From: Robert Thornton [REDACTED]
Sent: 25 January 2013 17:31
To: Peter Cleveland
Cc: Heather Micklethwaite
Subject: 1212 Mount Pleasant, Arundel - Re: Planning Consultation on: AB/138/12/L & AB/137/12/
Attachments: 1212-402A Proposed Section.pdf

Thank you for your email enclosing amendments and comments relating to 7 Mount Pleasant.

title
PROPOSED
ELEVATIONS

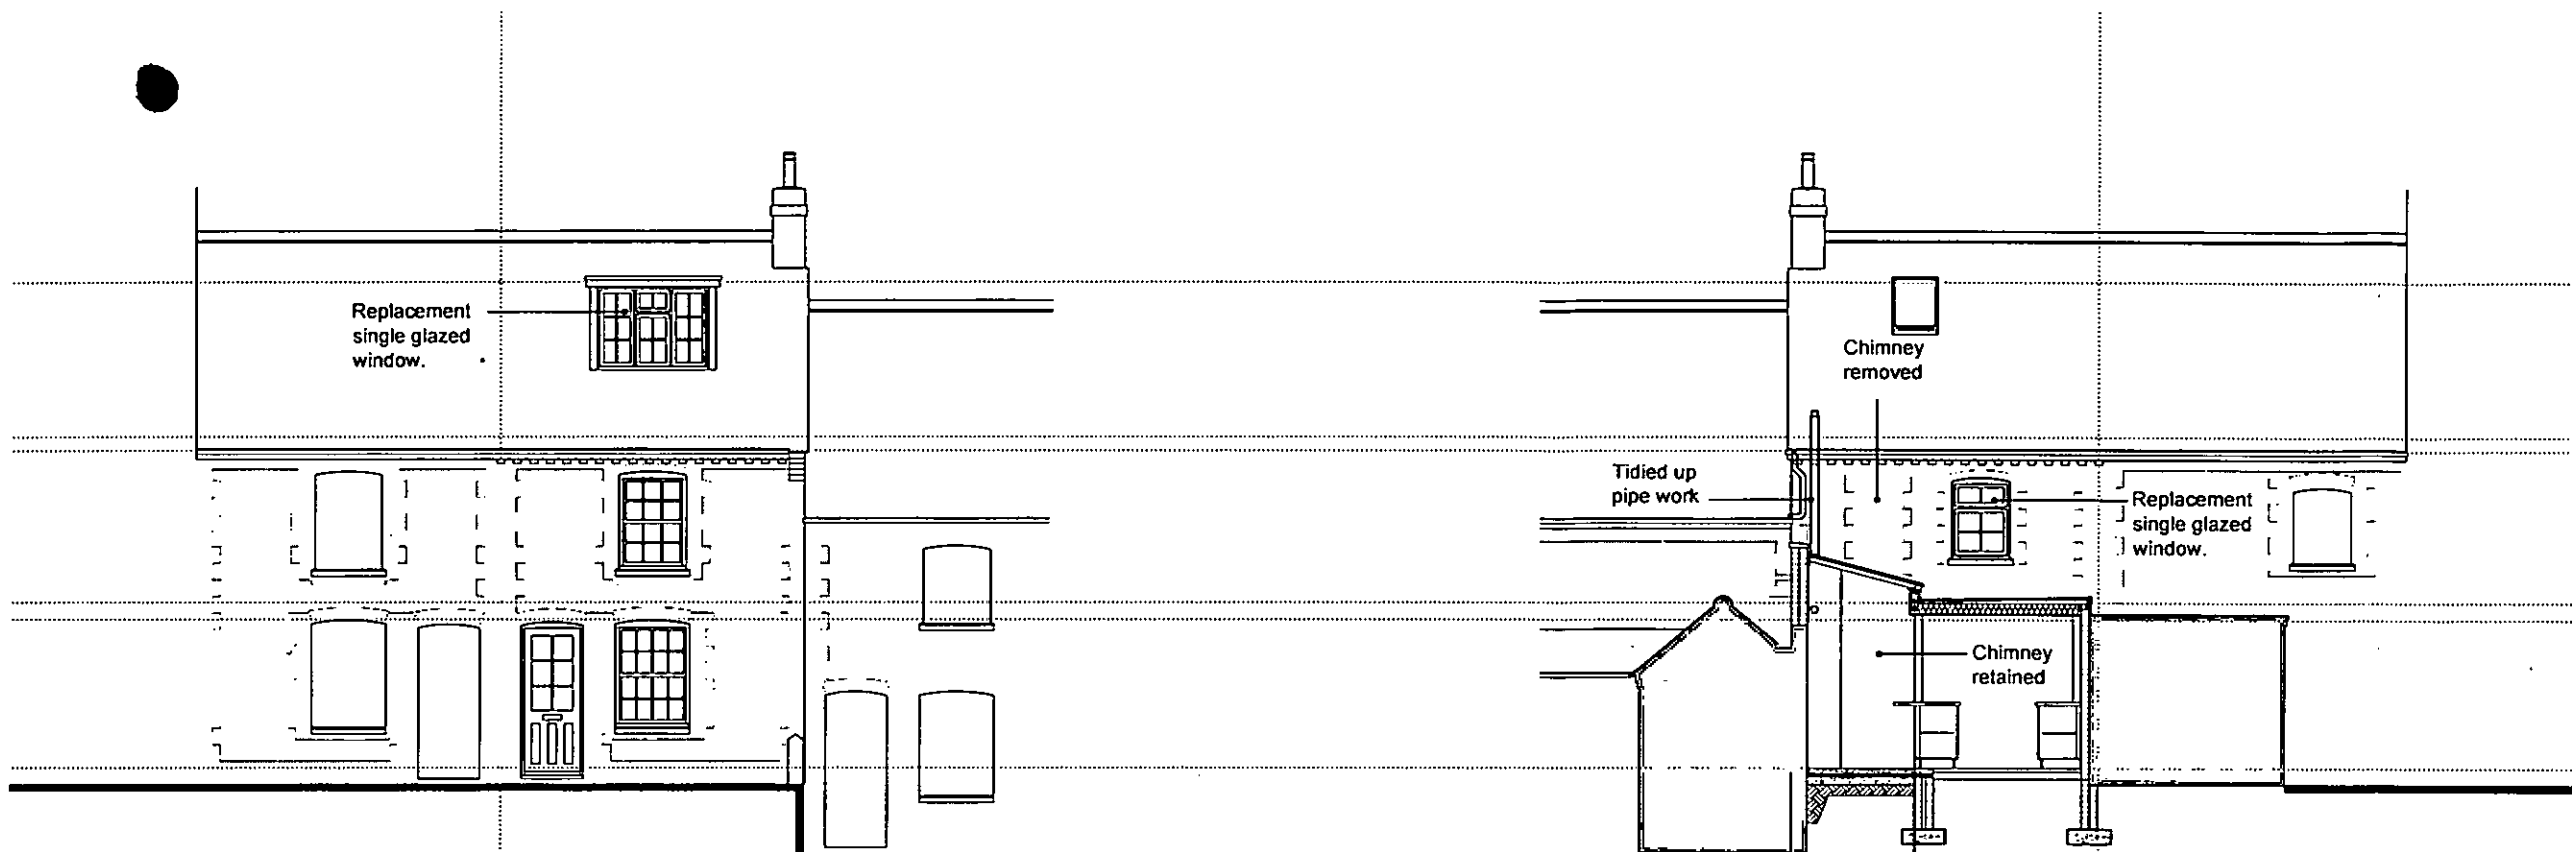
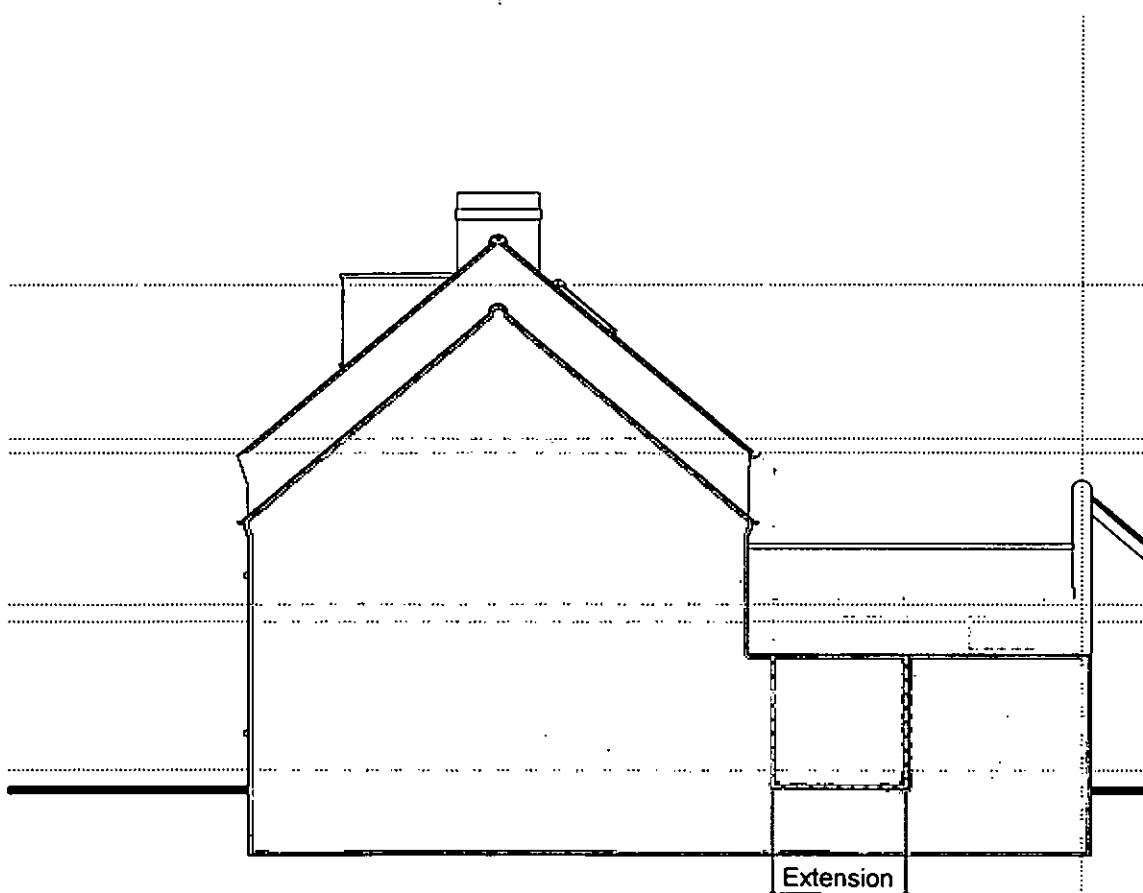
- 'Normal practice' relates to retaining and promoting single glazing in historic buildings (with the exception of rooflights and conservatories) to maintain and improve building character.

- It is difficult to justify double glazing on the basis of thermal performance, when the scheme proposes to open up and increase the ground floor and introduce a glass roof.

I am happy that the amended plans submitted previously can be accepted as substitute for the purpose of securing an approval. Please find attached an updated section drawing removing reference to double glazing.
